WEST SUSSEX COUNTY COUNCIL CONSULTATION

TO:	Arun District Council FAO: Maria Tomalova
FROM:	WSCC - Highways Authority
DATE:	13 September 2019
LOCATION:	The Crickets, Hoe Lane, Flansham, PO22 8NT
SUBJECT:	Y/74/19/PL Extension & alterations to main dwelling. Conversion of existing annexe to three holiday letting units.
DATE OF SITE VISIT:	N/A
RECOMMENDATION:	Advice
S106 CONTRIBUTION TOTAL:	N/A

Drawing P05 August 2019 Scale 1:100 @A3
Planning Drawing - Site Plan

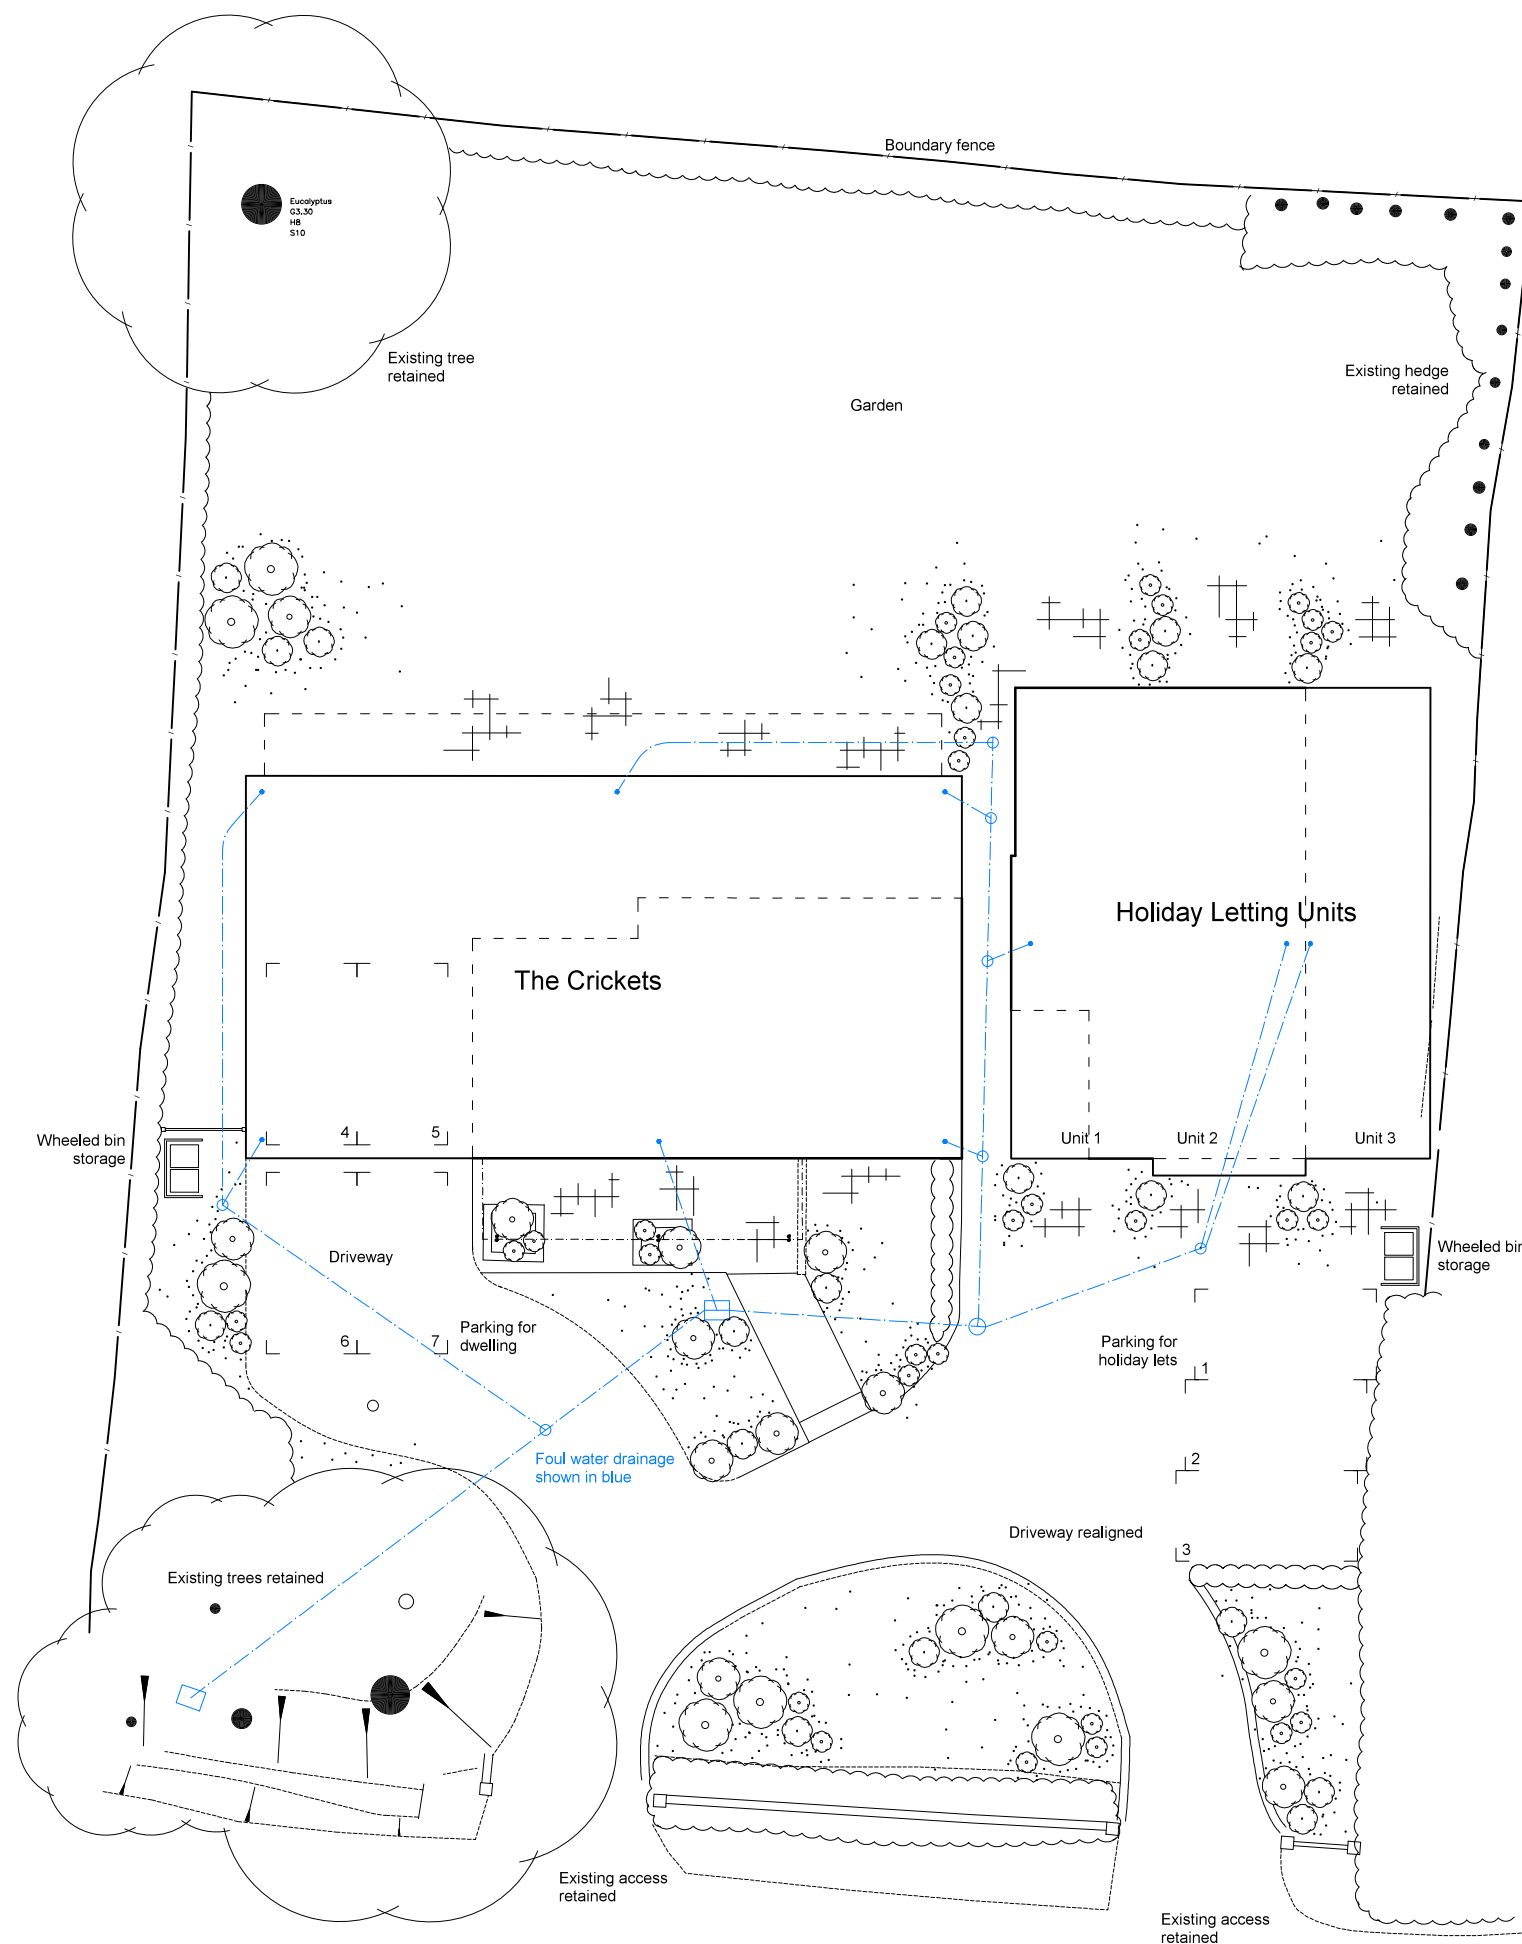
A double car garage and 2 parking bays are proposed for the main dwelling. The WSCC Car Parking Demand Calculator has indicated that a dwelling of this size in this location would require 3 car parking spaces. The proposed parking bays meet the minimum specifications for single car bays of 2.4m x 4.8m as set out in Manual for Streets (MfS). The garage has internal dimensions of approximately 5.7m x 5.9m, which does not meet the MfS minimum specifications for double car garages of 6m x 6m. The applicant is advised to enlarge the proposed garage to meet MfS specifications.

3 car parking spaces are proposed for the holiday lets. Each space meets the MfS minimum specifications of 2.4m x 4.8m. WSCC has recently adopted new parking guidance in August 2019. The new guidance does not include standards for holiday let parking demand.

The LHA would be minded to advise the planning authority to consider the parking demand as per pre-August 2019 guidance when considering the demand for this application. On this basis, the parking requirements for holiday lets are one parking space per bedroom. Each holiday let has one bedroom and one parking space. Therefore the proposed parking provision is considered sufficient to meet the demands of the site.

Car parking spaces (details approved)

No part of the development shall be first occupied until the car parking has been constructed in accordance with the approved site plan. These spaces shall thereafter be retained at all times for their designated purpose.
